Lirette Accessory Living Quarter, AL-21-18

Please accept the following comments from El Paso County Public Health for the special use project referenced above:

Site Plan – Residential Property  
PCD File No. AL-21-18

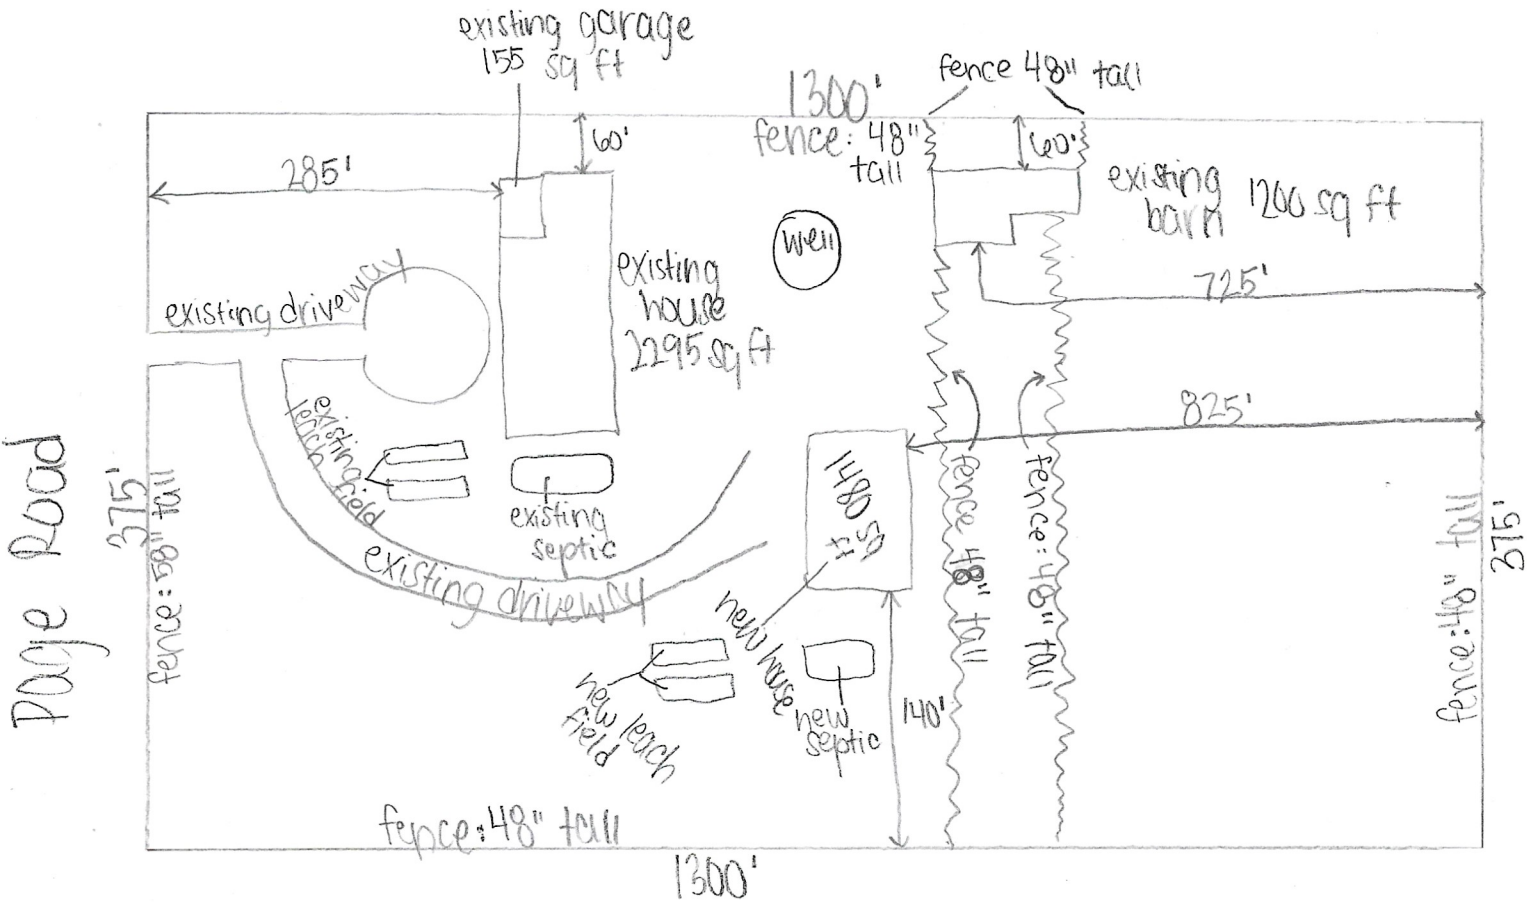
- Water service for the both the existing dwelling and the proposed second dwelling is by an existing individual private well.
- The onsite wastewater treatment system (OWTS) for the existing dwelling was installed and approved for a 3-bedroom house in 1993. The septic tank was replaced in 2016 and is sufficient for a 4-bedroom house; however, given the layout of the property connecting the proposed new dwelling to the existing septic tank may not be possible. Therefore, a permit to install a new OWTS for the proposed second dwelling may be necessary. The new OWTS components must meet the minimum horizontal installation setbacks from the well and all property lines.

- Suggest contacting a Licensed OWTS installer for possible connection possibilities to the existing OWTS.
- Please note: The existing soil treatment area must be adequate in size to accommodate the additional dwelling.

- The location of the existing soil treatment area (STA) must be located and protected from compaction during the installation of the second dwelling and any other associated OWTS excavating.
